M60/M62/M66 Simister Island Interchange

TR010064

7.26 APPLICANT'S RESPONSES TO DEADLINE 4 SUBMISSIONS

APPLICANT'S RESPONSES TO DEADLINE 4 SUBMISSIONS

FIGURE 2.3

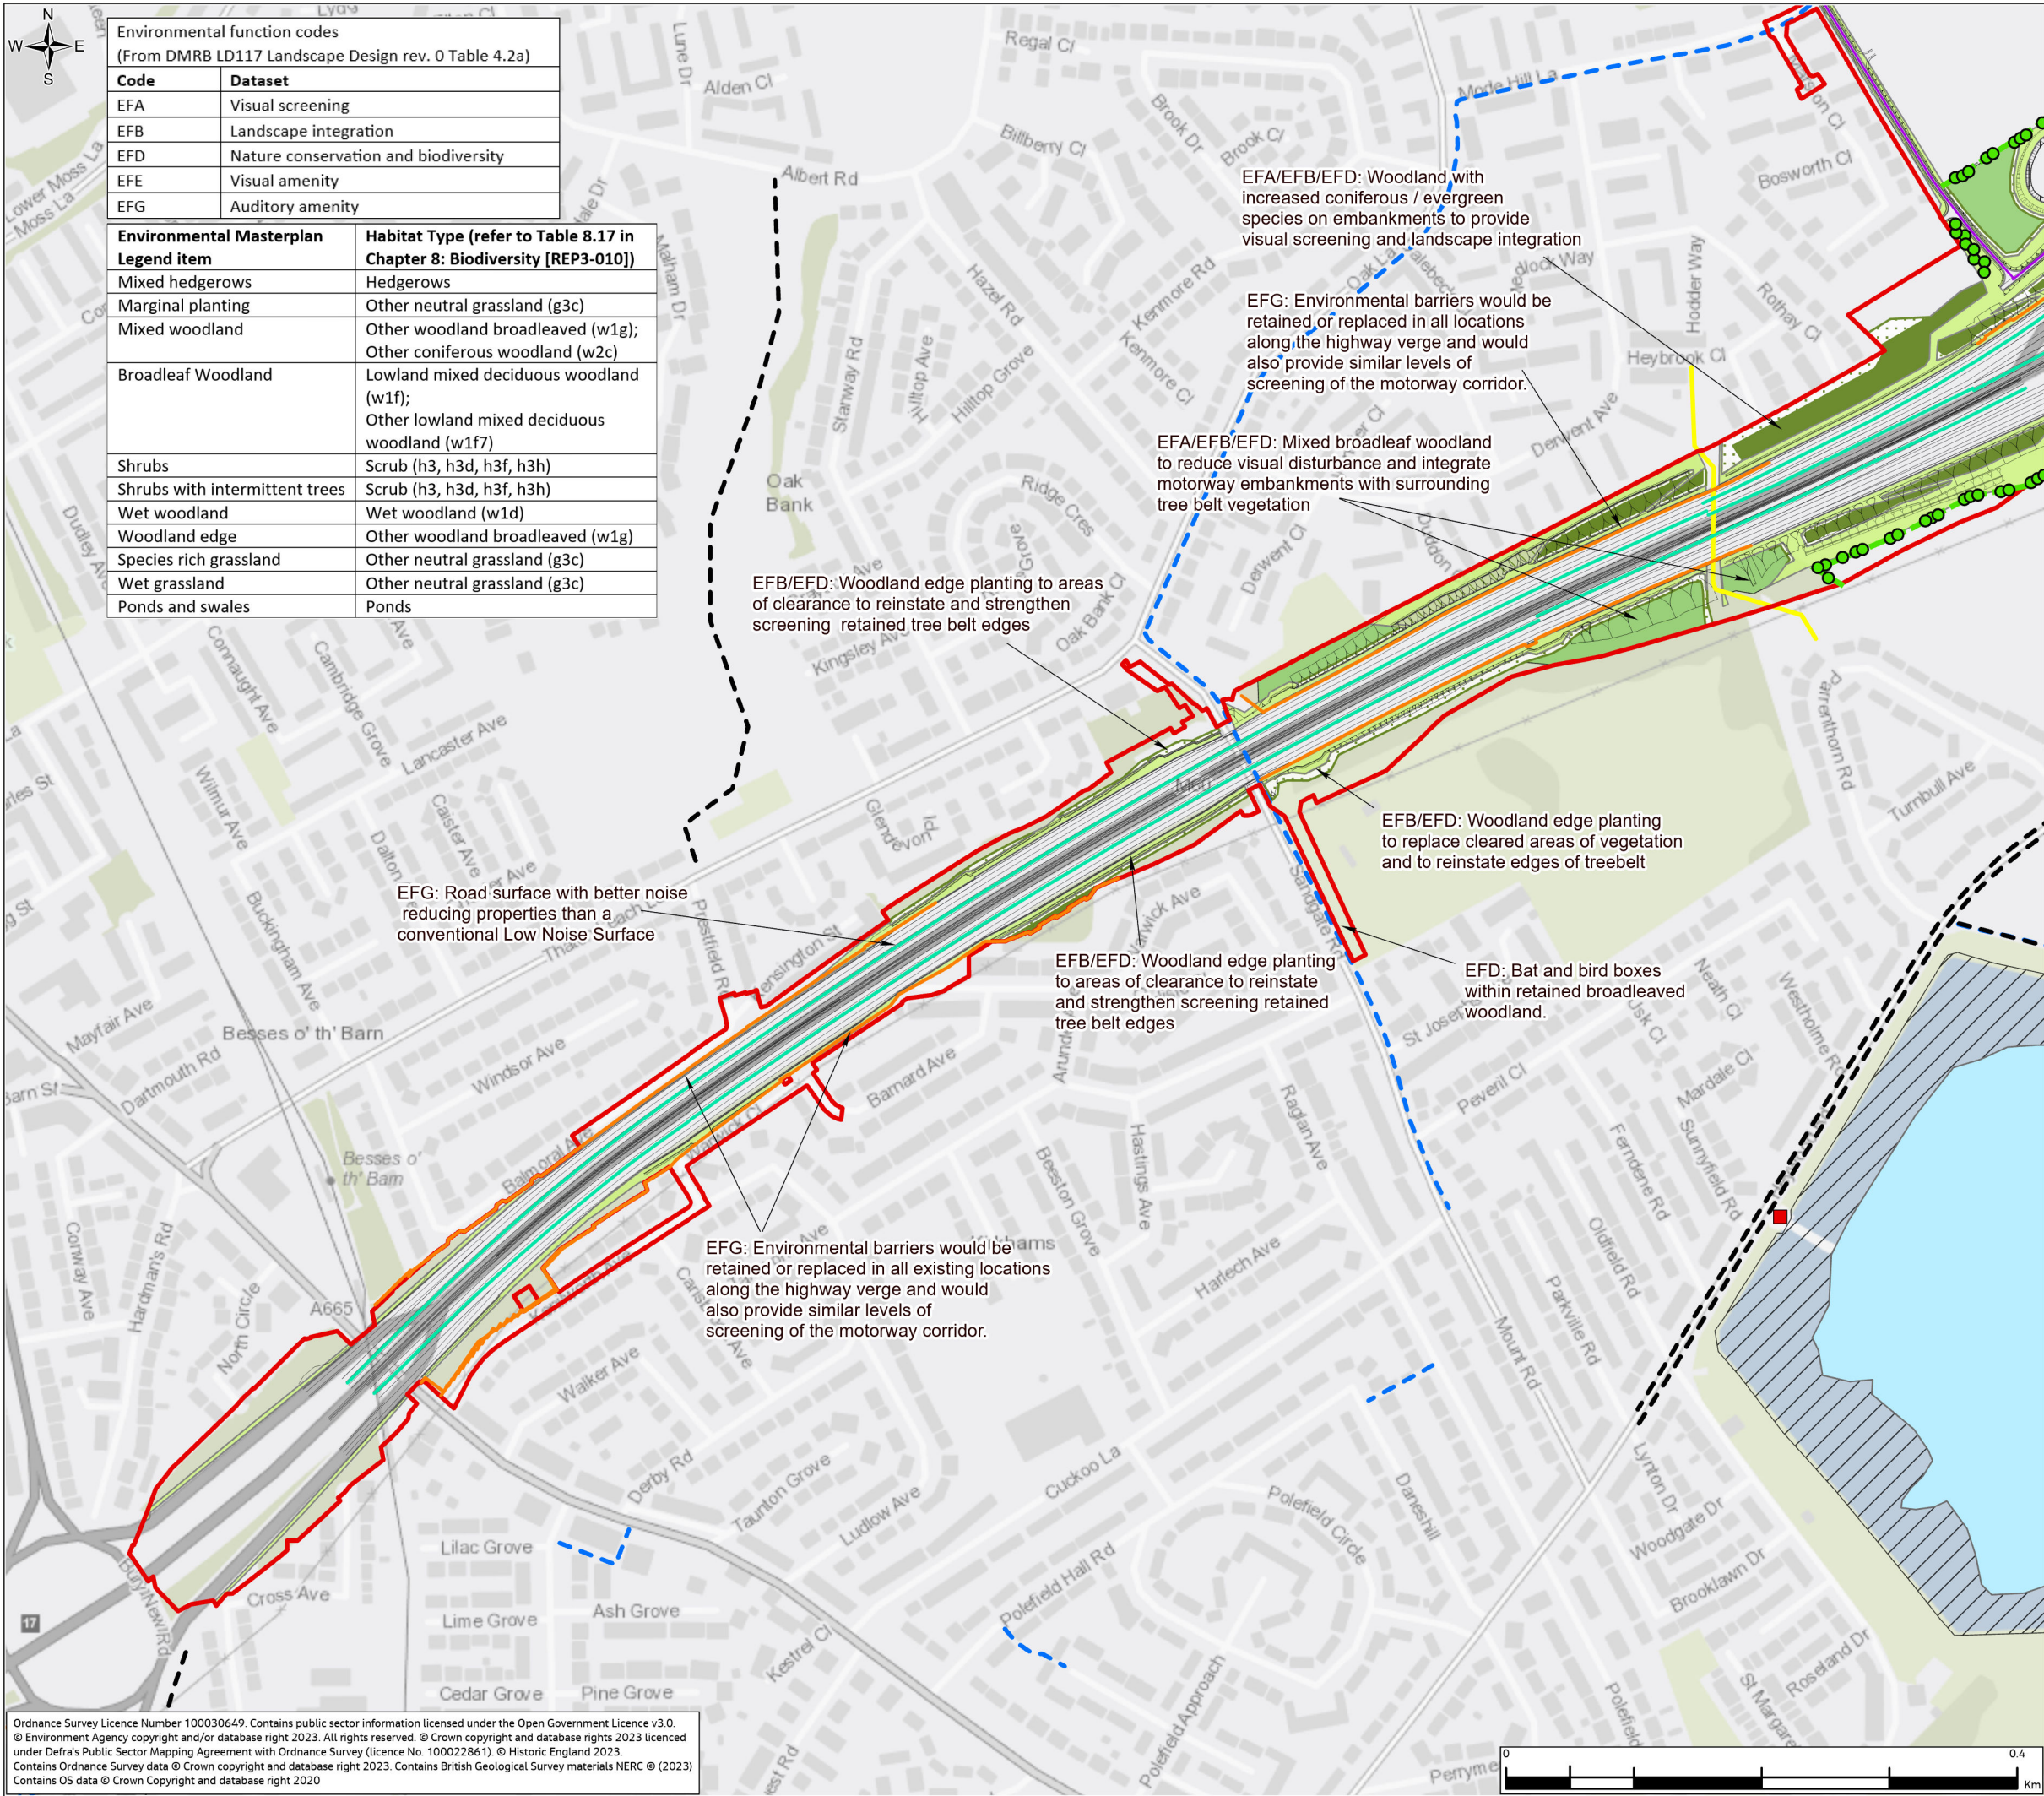
Reference	Hearing Action Reference / Other Reference	Action / Topic	Interested Parties Written Submission	Applicant's Response at Deadline 5
			<p>as mitigation proposals can be provided elsewhere. Figure 2.3 of the ES (Environmental Masterplan Sheet 2 of 5, APP-057) reveal indicative locations of tree planting, wet woodland, and log and brash piles. We submit that they do not require the Applicant to permanently acquire the entirety of both EMAs.</p> <p>1.10. Finally, the Applicant in its Response describes the acquisition of the EMAs as being "driven by the temporary works areas" and needed to "control and manage the remediation". This suggests that the EMAs are being acquired largely out of convenience, rather than any compelling need. The result is that the Hillary Family is taking on most of the burden of environmental mitigation despite a lack of evidence as to the need for that to be the case.</p>	<p>Please refer to the Applicant's response to ISH2 Action 30 [REP4-028] in relation to 1.8 of the Interested Party's written submission where the Applicant describes the requirements for visual screening during operation. The Applicant confirms that receptors at representative viewpoints VP3, VP5 and VP7 would experience moderate adverse (significant) effects due to views of the Northern Loop and Simister Pike Fold Bridge, and views of moving traffic on the elevated structures in the Scheme opening year. With mitigation planting on the Simister Pike Fold Bridge embankments and Northern Loop the effects would reduce to slight adverse (not significant) by year 15 as reported in Chapter 7 Landscape and Visual of the Environmental Statement [APP-046]. A slight adverse (not significant) effect has been assessed at VP4 during both operation year 1 and year 15.</p> <p>Please refer to the Applicant's response to ISH2 Action 30 [REP4-028] in relation to 1.9 of the Interested Party's written submission which details which essential mitigation is proposed within the environmental mitigation areas.</p> <p>Please refer to the Applicant's response to ISH2 Action 30 [REP4-028] in relation to 1.10 of the Interested Party's written submission which details which essential mitigation is proposed within the environmental mitigation areas. The ability to control and manage the remediation of land required for temporary works will enable the Applicant to ensure the optimum conditions for establishment of this mitigation planting and hence contribute to the likely success of the mitigation planting. In addition, by using these temporary works areas for essential environmental mitigation, the overall land take for the Scheme is reduced compared to siting environmental mitigation outside of these areas.</p>

<p>REP4-031g</p>	<p>Written Submission of Oral Case</p> <p>ISH2 Action 30 and ISH2 Action 31</p>	<p>Environmental Mitigation – Site Selection</p>	<p>2.2 The Hillary Family considers that the Application materials do not adequately justify the disproportionate burden of environmental mitigation proposed to be located in the north eastern 'quadrant' of the scheme. This is particularly evident in the lack of environmental mitigation in the NW and SW quadrants. Whilst small parcels of land are proposed for environmental mitigation purposes, there exists an opportunity to allocate additional land here for any required mitigation. The NW quadrant has been allocated for use as the site compound and materials storage area. This land is to be disturbed as a result and, whilst a small area has been allocated to accommodate an attenuation pond and an area of environmental mitigation and tree screening, a large area to the south of Mode Hill Lane (approx. 15.5 acres) remains available for further environmental mitigation on land not allocated for alternative development. The Hillary Family contends that this area, being contiguous to and easily accessible from an existing residential area could be provided for environmental mitigation and could also serve as an area of public amenity for local residents. A greater area than is currently allocated in the SW quadrant could also be utilised for environmental mitigation both to the west and east of Corday Lane. This totals approximately 8 acres on land not allocated for alternative development.</p> <p>2.3. In summary the Hillary Family considers believe the proposed</p>	<p>The Applicant's response to ISH2 Action 30 [REP4-028] explains that some of the environmental mitigation is site-specific and needs to be delivered within the north-east quadrant to be effective, including mitigation for bats, for integration of attenuation pond 1, to mitigate impacts to the Landscape Character Area, to mitigate visual impacts to residents, walkers on footpaths and visitors to Pike Fold Golf Course (VP3, VP5 and VP7), and to integrate the Northern Loop into the landscape.</p> <p>The Applicant's response [REP4-028] also explains that, by siting areas of non-site-specific habitat creation, to ensure no overall loss of biodiversity, in and around mitigation for specific receptors/impacts (bats, drainage, visual impacts), the Applicant maximises the value of these habitats as it is an established ecological principle (Making Space for Nature, Lawton 2010) that habitats which are bigger are more valuable compared to multiple smaller fragments of an equivalent total size.</p> <p>For the reasons outlined above, the Applicant considers that the design presented on Figure 2.3 Environmental Masterplan of the Environmental Statement Figures [APP-057] is the optimum solution for environmental mitigation.</p>

Reference	Hearing Action Reference / Other Reference	Action / Topic	Interested Parties Written Submission	Applicant's Response at Deadline 5
			location of the environmental mitigation areas on the Hillary Land to be inequitable, and (per the submissions at CAH1) that a compelling case to acquire the full extent of the Plots has not been made out.	
REP4-031h	Written Submission of Oral Case ISH2 Action 30 and ISH2 Action 31	Impact on Bats	<p>2.4 Further to the Hillary Family's submissions at CAH1, the Hillary Family note that the Applicant proposes to disturb a significant amount of potential bat roosting and foraging habitat in the clearance of the land in the NE quadrant of the scheme both on land required to construct the Northern Loop but also in clearing land required for temporary site compounds and soil storage, an area of approximately 27 acres.</p> <p>2.5. As above, Chapter 8 (Biodiversity) of the ES confirms (at 8.10.100) that no bat roosts exist within the Order limits and that should roosts be found during construction they will be mitigated by use of bat boxes. The Applicant concludes that the effect on roosting habitat is neutral. At 8.10.106 the Applicant confirms that whilst foraging habitat is lost, it would be small in relation to the overall amount of habitat available in the surrounding area. At 8.10.108 they confirm that the integrity of bat resource is not considered likely to be affected due to the mobility of bats and the availability of alternative foraging habitat in the wider landscape. The Applicant confirm that the effect on foraging habitat is neutral. In regard to habitat fragmentation the Applicant express some concern (at 8.10.109 - 8.10.111 inclusive) that commuting routes in the NE quadrant will be lost by virtue of the loss of just two hedgerows which they intend to replace with new hedgerow planting, though they acknowledge that the new vegetation would take time to mature. They anticipate that construction will take 2-3 years and it would be reasonable to assume that the hedgerows will take 3-5 years to mature, and so bat habitat will be affected for 5-7 years, during which there will be no bat resource other than that found in the wider landscape. The Hillary Family's considers that it would be reasonable to assume that the bat population, being mobile, will seek and find alternative habitat. As and when they do return, all vegetation around the northern loop will have matured and provide suitable roosting, foraging and commuting locations. At 8.10.114 and 8.10.115 the Applicant confirms that the bat species observed are light-tolerant species that can forage in a wide variety of habitats and that light spill would not impact foraging or commuting bats.</p>	<p>The Applicant refers to its response to ISH2 Action 30 [REP4-028] and to its response to ExQ2 BIO.2.1 provided at Deadline 5 of the Examination in relation to 2.4 of the Interested Parties written submission.</p> <p>Page 5 of 7 of Figure 8.3.1 within Appendix 8.3 Bat Survey Report [APP-091] shows the distribution of trees with bat roost potential within the north-west quadrant. A single tree with low bat roost potential (BT2) is located along Egypt Lane.</p> <p>Paragraph 8.10.105 of Chapter 8 Biodiversity of the Environmental Statement [REP3-010] summarises the loss of foraging habitat across the entire Order Limits, a total area of 31.13ha (and 0.88km of hedgerow). Of this, 9.97ha of bat foraging habitat and 378m of hedgerow are located within the land owned by the Hillary family.</p> <p>The assessment presented in paragraph 8.10.100 to 8.10.116 of Chapter 8 Biodiversity of the Environmental Statement [REP3-010] is an assessment of residual impacts, i.e. impacts from the Scheme with the implementation of mitigation which includes the provision of habitats in accordance with Figure 2.3 Environmental Masterplan of the Environmental Statement Figures [APP-057].</p>
